RE: Cloverleaf Filing 2 – Pond 1 Rock Chute and Basin, Pond 2 Spillway Analysis and Justification

The EPC PA punchlist from the 7-13-2023 site walk identified that the Pond 1 Rock Chute/Basin and the Pond 1 Spillway geometry required further engineering review of the as-built condition and engineer of record acceptance of the as-built condition.

POND 1 PLAN

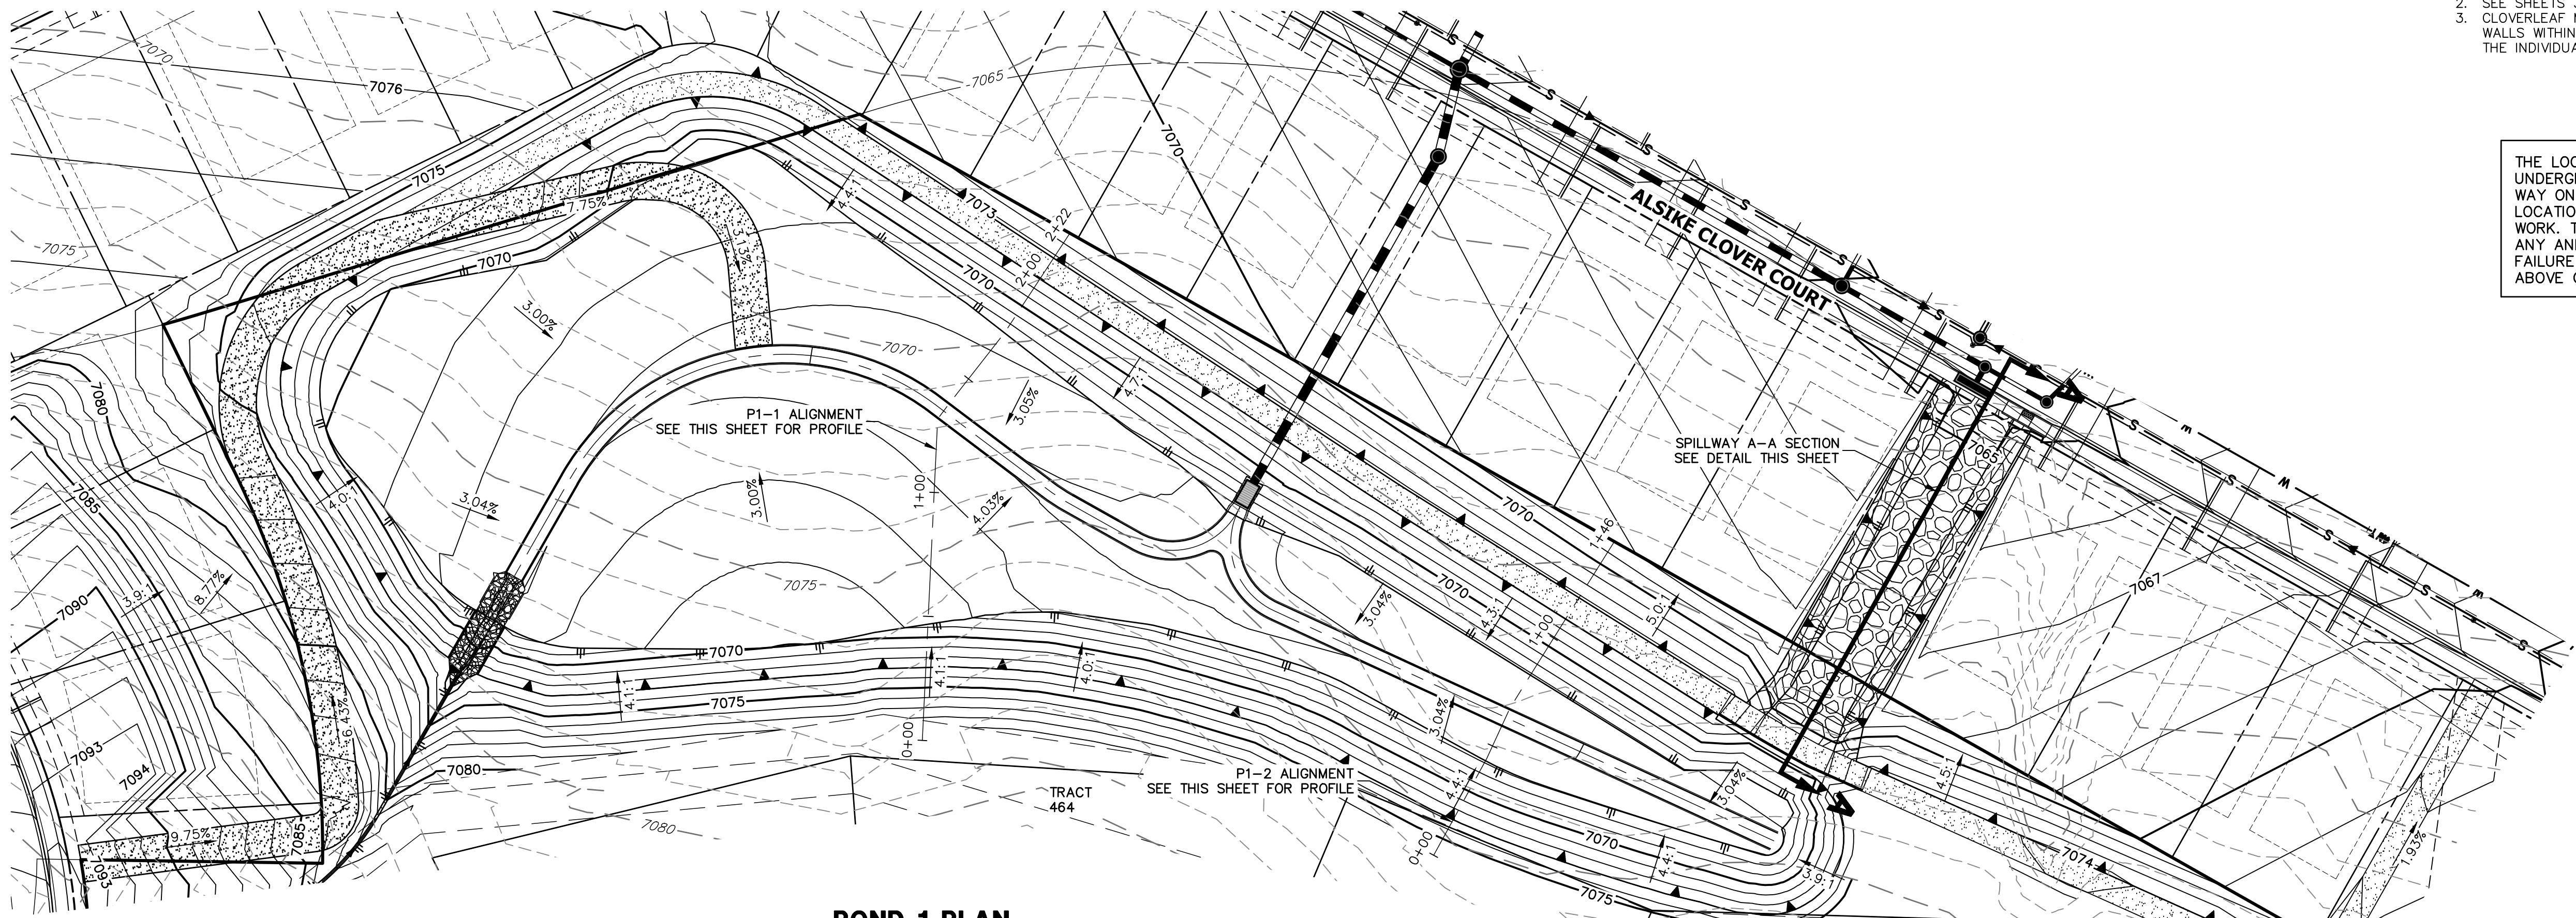
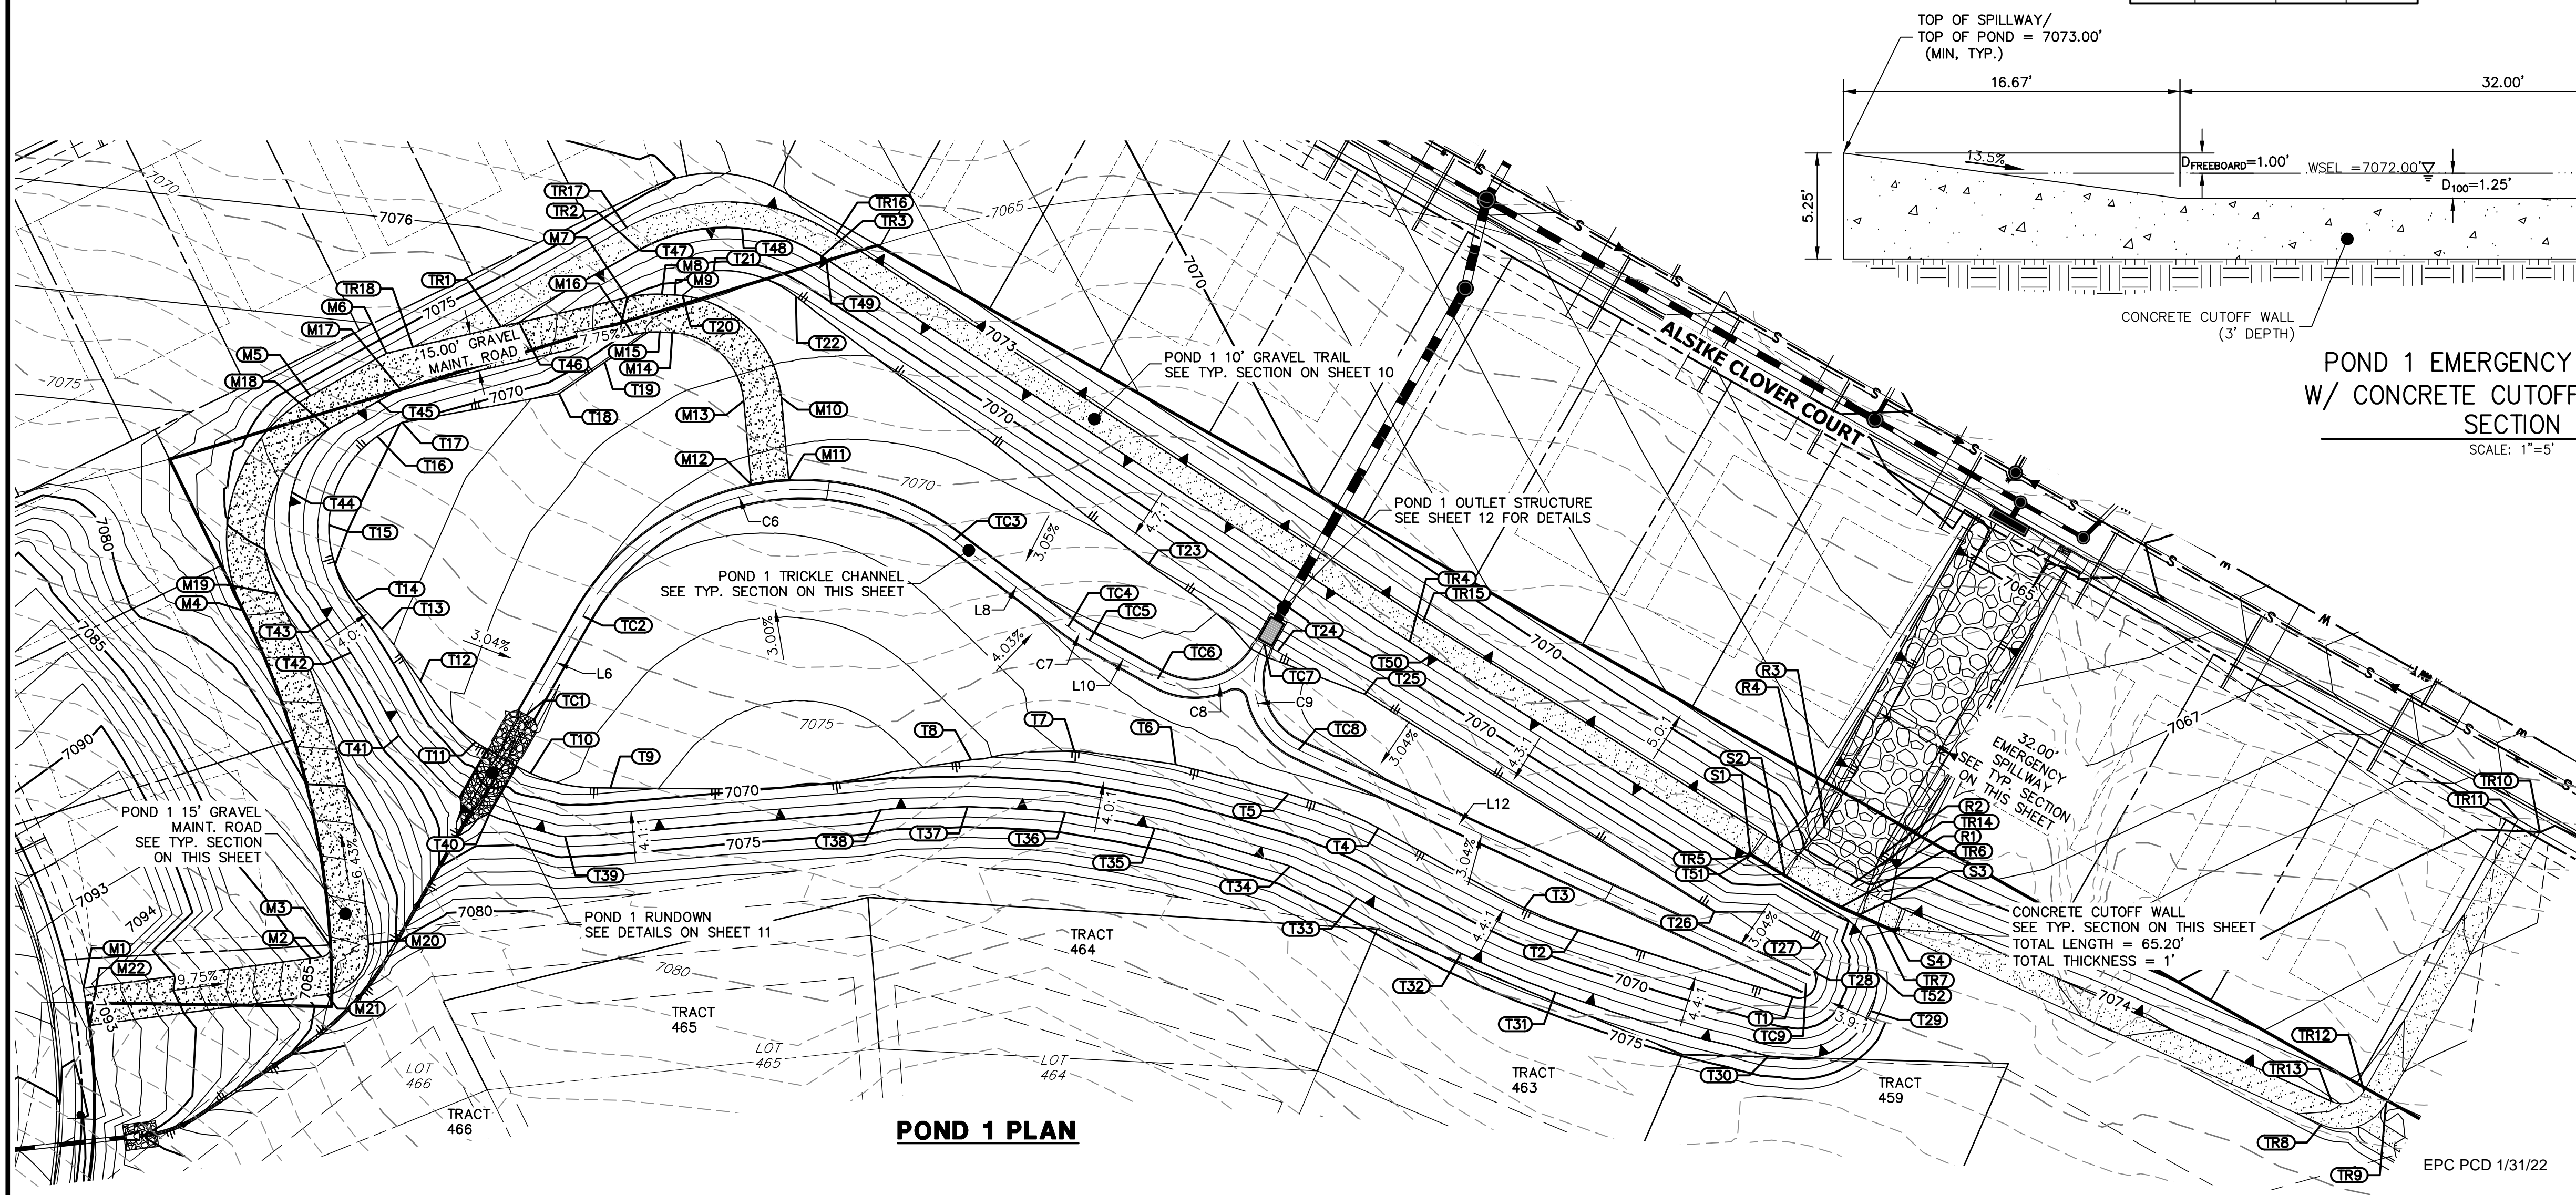
With regard to the rock chute entry at the east side of Pond 1, the as-built condition eliminated the rip-rap basin. In JR Engineering's opinion, the as-built rock chute entry will function adequately without the basin since the rock chute slope softens from 25% to approximately 5% and the rock chute directly connects to the 7 ft. wide concrete trickle channel.
